## Yorkshire Green Energy Enablement (GREEN) Project

### The Examining Authority's first written questions and requests for information (ExQ2)

#### Responses of North Yorkshire Council

Figure 16: Shipton North Cable Sealing End Compound Illustration (as detailed in Key at 3.3.2 above)

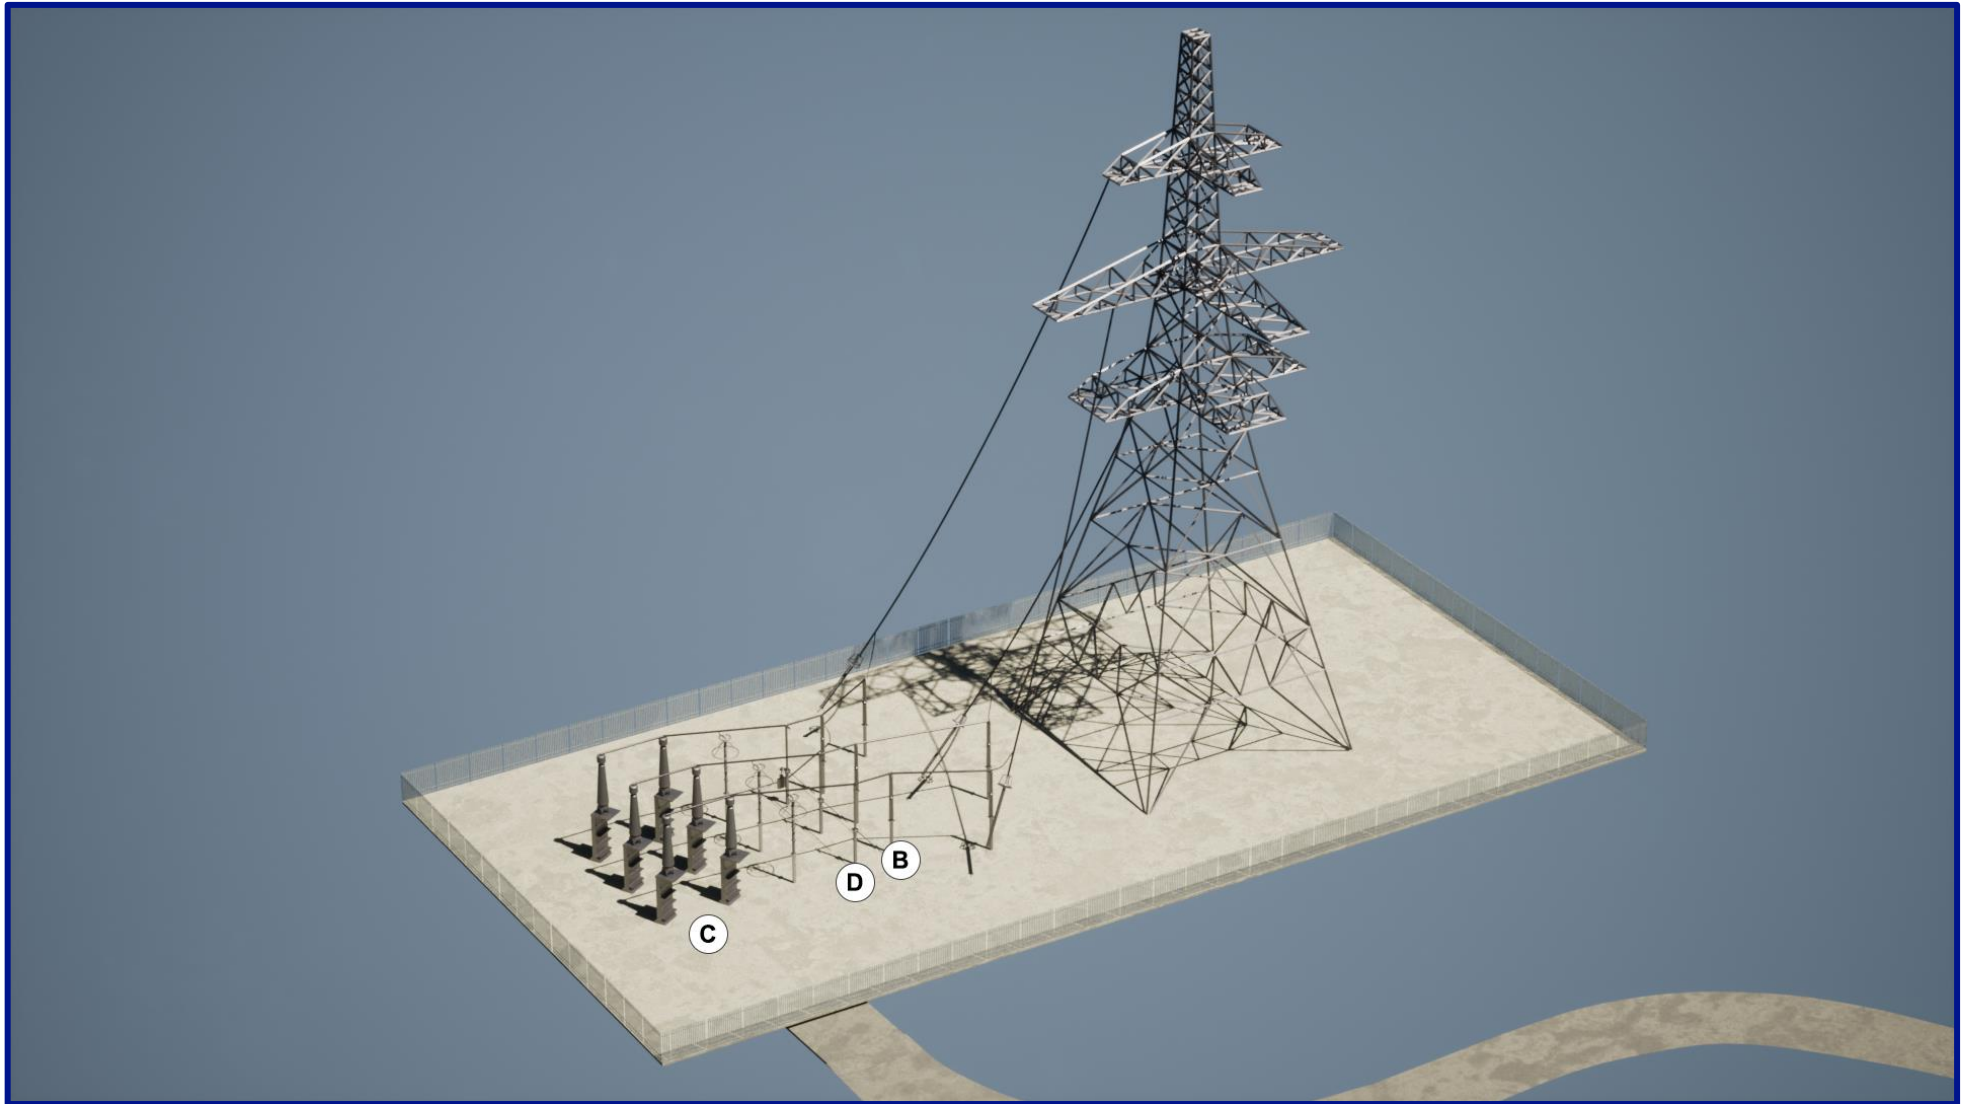
3.1 Illustrations of the proposed Cable Sealing End Compounds (CSEC’s) are provided within the DASSI. The illustration of the Shipton North CSEC can be viewed at Figure 16 on page 36.

3.2 The CSEC would require a change of use of agricultural land to create the compound for the CSEC and would be inappropriate development for the reasons set out in the response to a) above. Furthermore, each compound would require new surfacing, boundary fencing and equipment which would fall within the definition of structures and in some cases, including, the CSEC at Shipton North, the CSEC’s would include a new Pylon. For the above reasons these structures would fall within the definition of buildings due to their size, permanence and physical attachment to the ground.

3.3 NYC are therefore, of the opinion that the CSEC at Shipton North within the York Green Belt would be inappropriate development.
